**Rezoning Transportation Analysis**  
**Petition Number: Insert Zoning Petition #2021-056**  
*General Location Identifier: 04105416*

**Revision Log:**

Date	Description
05-27-2021	First Review (EL)
08-24-2021	Second Review (BB)
09-24-2021	Third Review (BB)
10-18-2021	Fourth Review (WB)
01-27-2022	Fifth Review (PDM)

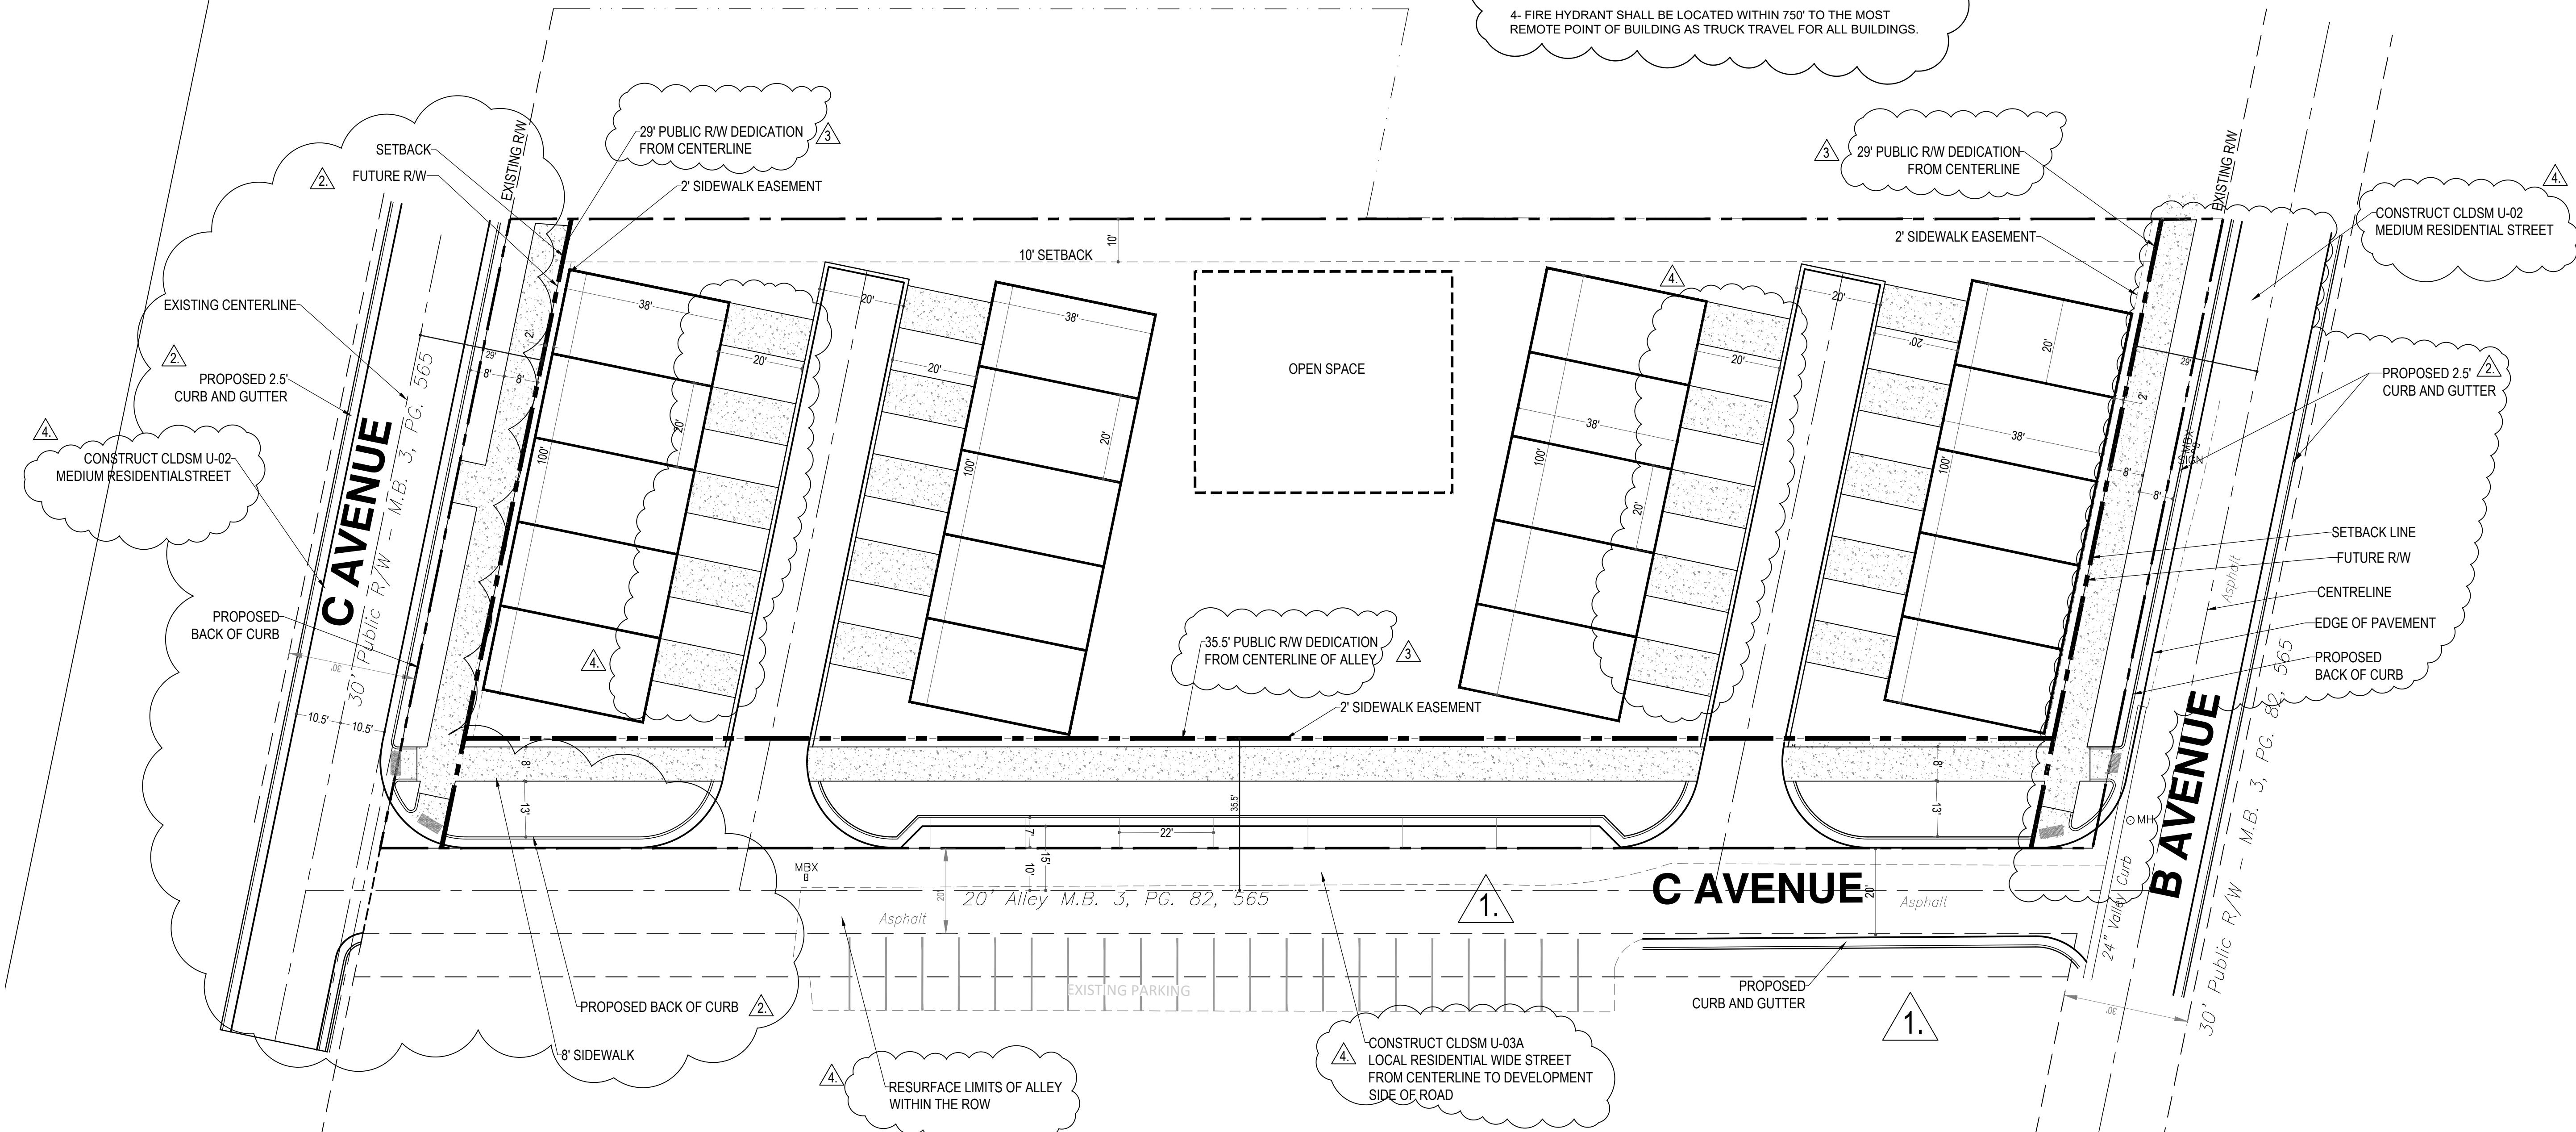
9. **New Comment (revised on 01/27/2021 based on updated site plan):** Revise site plan and conditional notes to specify Avenue B and Avenue C (formerly labeled as North Ave) as residential medium streets per CLDSM U-02. The site plan shall call out each road as CLDSM U-02. A conditional note shall be added to the plans stating Avenue B and Avenue C (formerly labeled as North Ave) will be constructed to the standard outlined in CLDSM U-02.

- 10. **New Comment (revised on 01/27/2021 based on updated site plan):** Revise site plan and conditional notes to specify Avenue C alley as residential wide streets per CLDSM U-03A. The site plan shall call out the road as CLDSM U-03A. A conditional note shall be added to the plans stating Avenue C Alley will be constructed to the standard outlined in CLDSM U-03A from the centerline of the road to the development side of the road as outlined in previous memo comment 1.C.
- 11. **New Comment (revised on 01/27/2021 based on updated site plan):** Revise site plan and conditional notes to commit to resurfacing the entire limits of C Avenue Alley within the right-of-way in accordance with the pavement schedule outlined in CLDSM U-03A. This includes the area from the centerline of the road to the right of way line to the west side of the roadway.

- 12. **New Comment (revised on 01/27/2021 based on updated site plan):** Revise site plan to relocate the multi-use path along C Avenue alley to reduce the planting strip to 8ft along the roadway (locate multi-use-path 10.5 feet from the edge of travel lane). Based on the current site plan for the townhomes, the setback from the right-of-way required by zoning is not met. Confirm setback requirements with zoning. Right-of-way dedication can be reduced to 2ft behind the relocated multi-use path (30.5 ft from centerline).
